Office of
Environment
& Heritage

DOC19/334952
SSD9741

OEH comments on Notice of Exhibition – Lane Cove West Data Centre – 1 Sirius Road, Lane Cove West (SSD 9741)

OEH comments on Notice of Exhibition – Lane Cove West Data Centre – 1 Sirius Road, Lane Cove West (SSD 9741)

Project Status	SSD	
Drawing Title	MASTER PLAN - EGRESS DIAGRAM	
Drawing Number	ATSYD2_SSD_DRG_ARC_0900

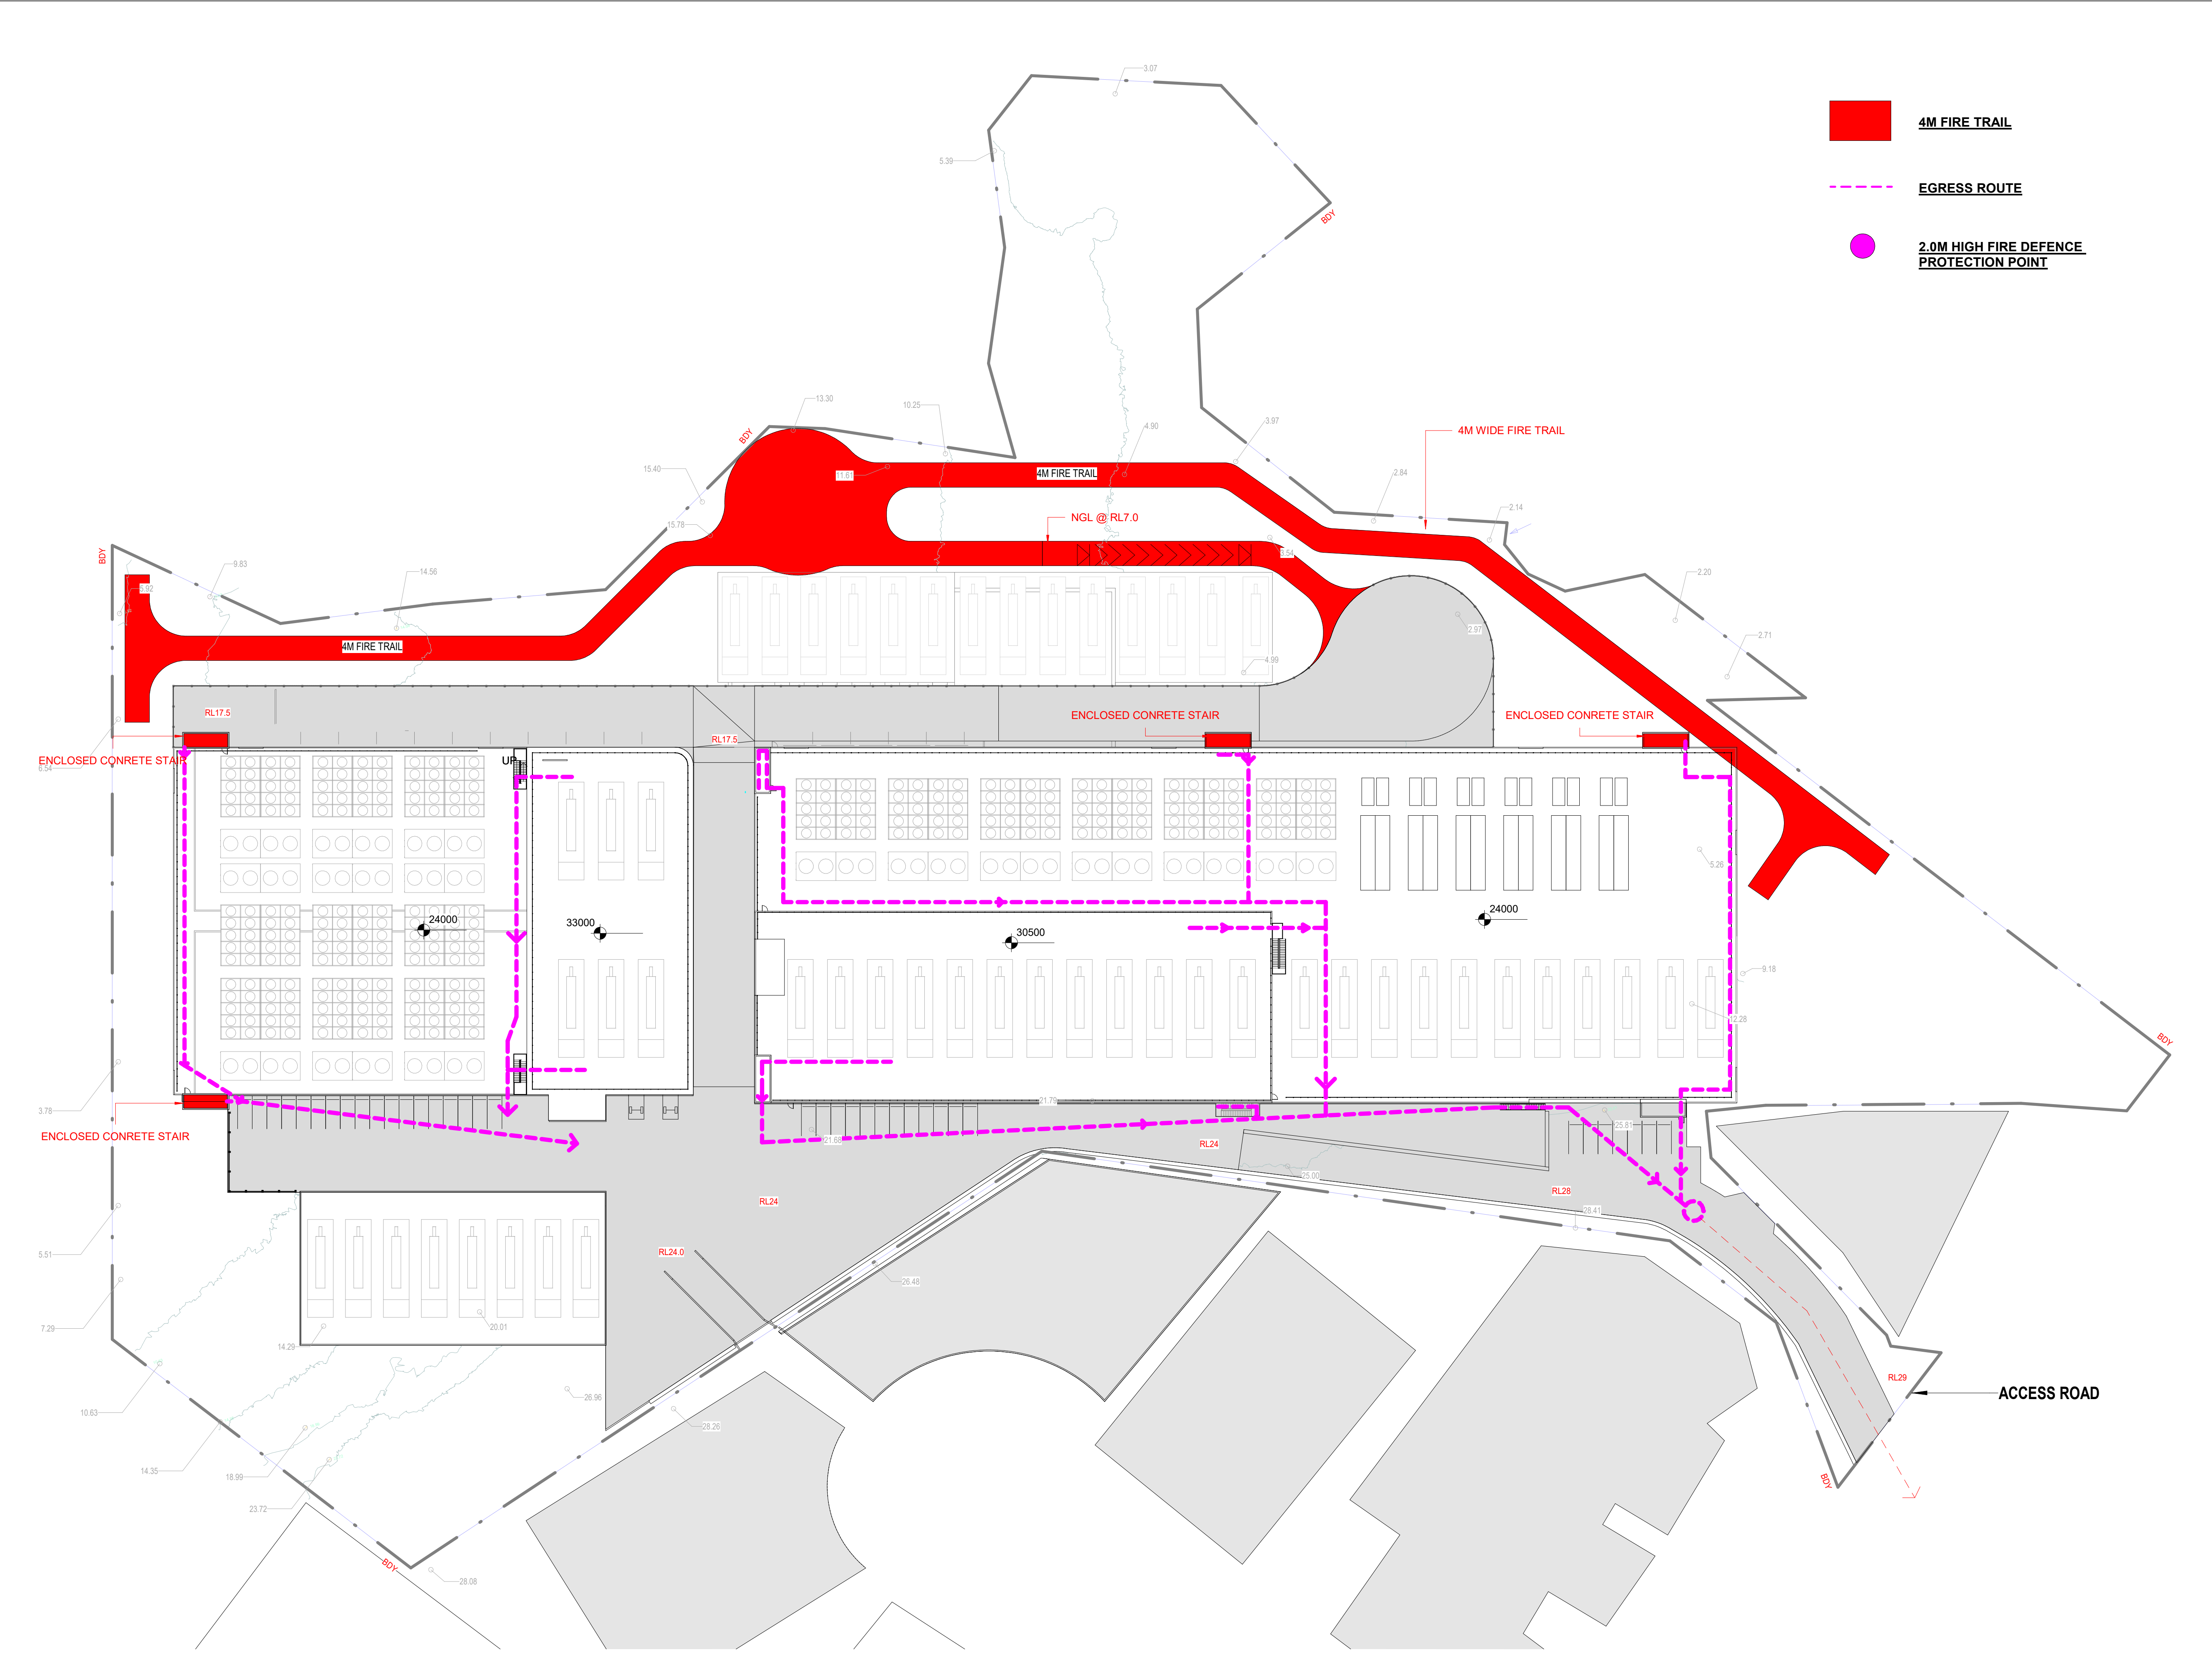
- Schedule 1 (Bushfire Protection Measures) in the BPA shows the APZ and fire trail are located outside the riparian corridor of Stringybark Creek
- The Architectural Plan – Master Plan – Hydrant Point and the Landscape Masterplan show part of the fire trail is proposed to be located within the riparian corridor along Stringybark Creek
- Schedule 1 (Bushfire Protection Measures) in the BPA shows the riparian buffer of Lane Cove River within the site as an APZ
- Schedule 1 (Vegetation Management Works Plan) in the VMP shows the riparian buffer of Lane Cove River within the site is to be planted with fully structured revegetation Smooth-barked Apple – Red Bloodwood Open Forest

It is recommended the inconsistencies are amended and the proponent clarifies if APZs are proposed to be located within the riparian corridors as it is unclear.
